Response to Planning application from Hertfordshire County Council (T and CP GDP Order 2015)

District ref: 6/2022/1943/FULL
HCC ref: WH/13629/2022
HCC received: 1 September 2022
Area manager: Matthew Armstrong
Case officer: Steven Knight

LAND BETWEEN 48 & 50 THE RIDGEWAY CUFFLEY EN6 4BA

Erection of a new dwelling with associated landscaping works

Drawing Number: **086 PL 02**

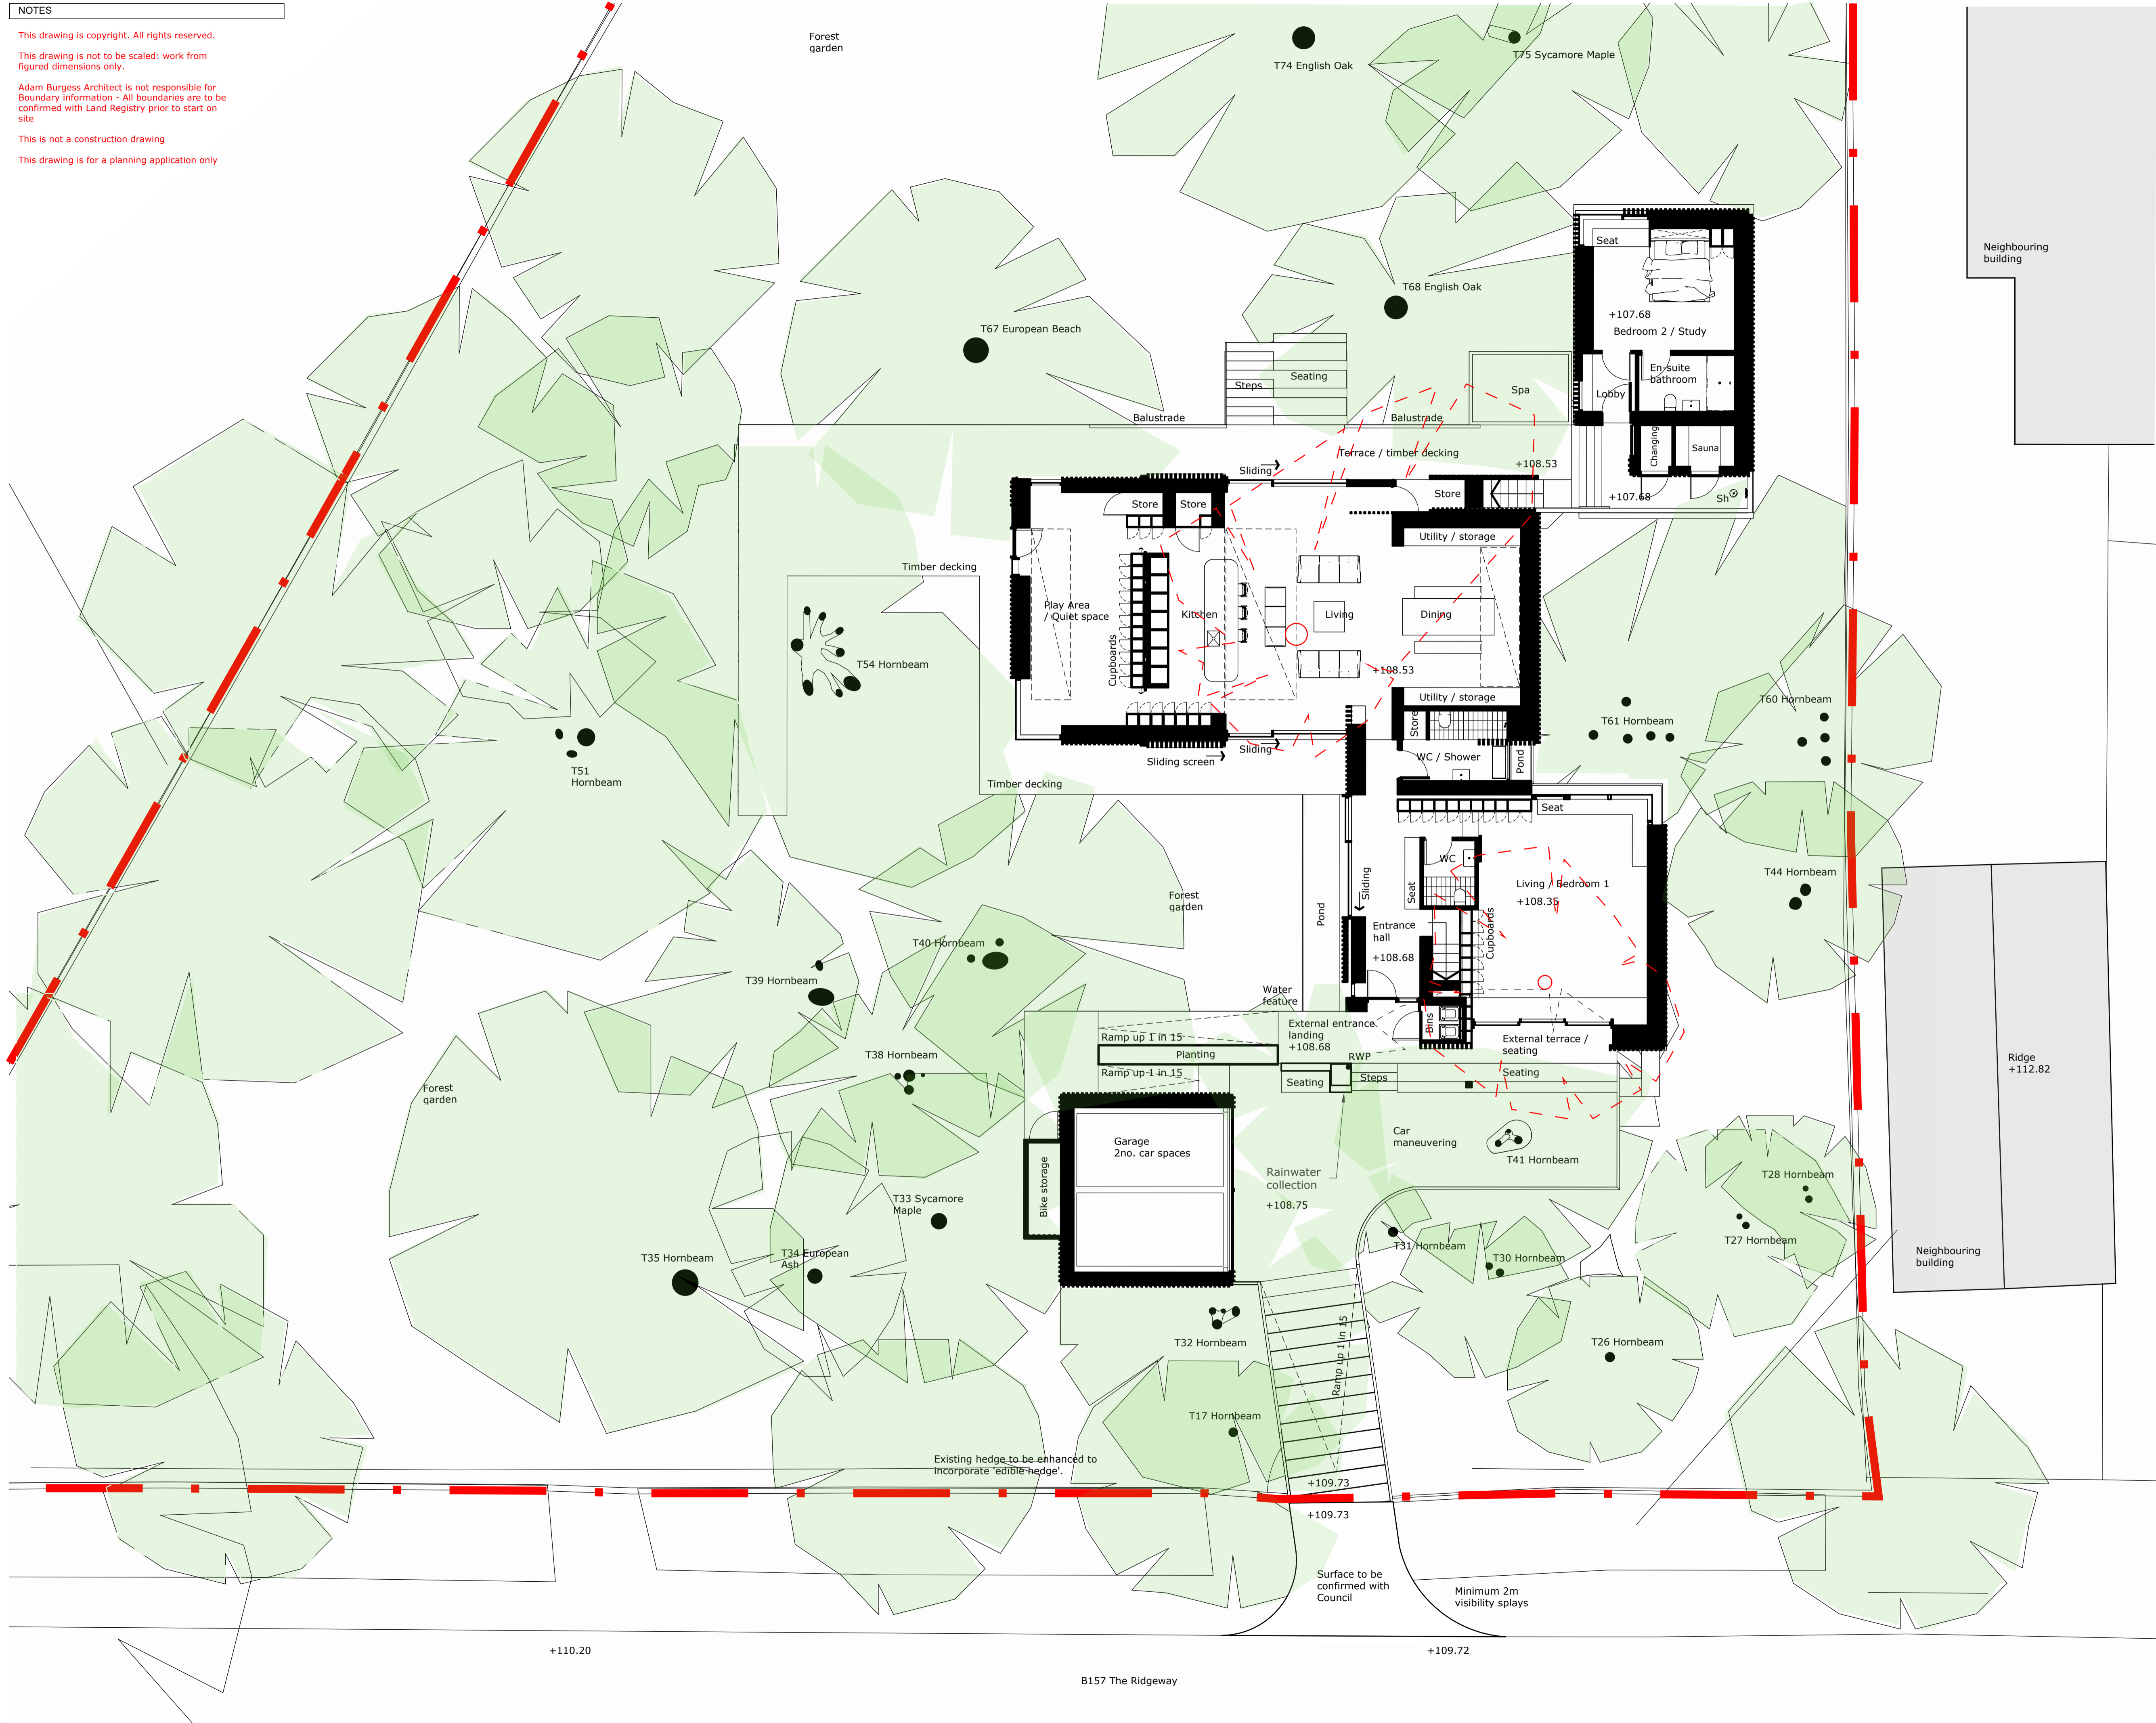
- a) Clarity over the design of the vehicle access and how it will cross the ditch
- b) Evidence that adequate visibility splays can be achieved

The Planning Statement states that access will be via an existing dropped kerb which appears to consist of four flat kerbs. However, until now, this access has presumably only been used for

occasional access to the wooded area for maintenance purposes and its suitability for use as a residential access need to be evidenced. Firstly, the Site Plan needs to demonstrate that adequate visibility splays if 2.4m x 66m can be achieved. Whilst the existing hedgerow is to be removed, it needs to be ensured that any proposed landscaping or boundary treatments will not obstruct visibility. Secondly, the design of the vehicle crossing needs to be clarified. It is currently a dropped kerb but is shown on the plan as a bell-mouth. Thirdly, there is no information about whether the ditch is currently culverted at this point and what works will need to be undertaken to ensure the ditch remains free from obstruction.
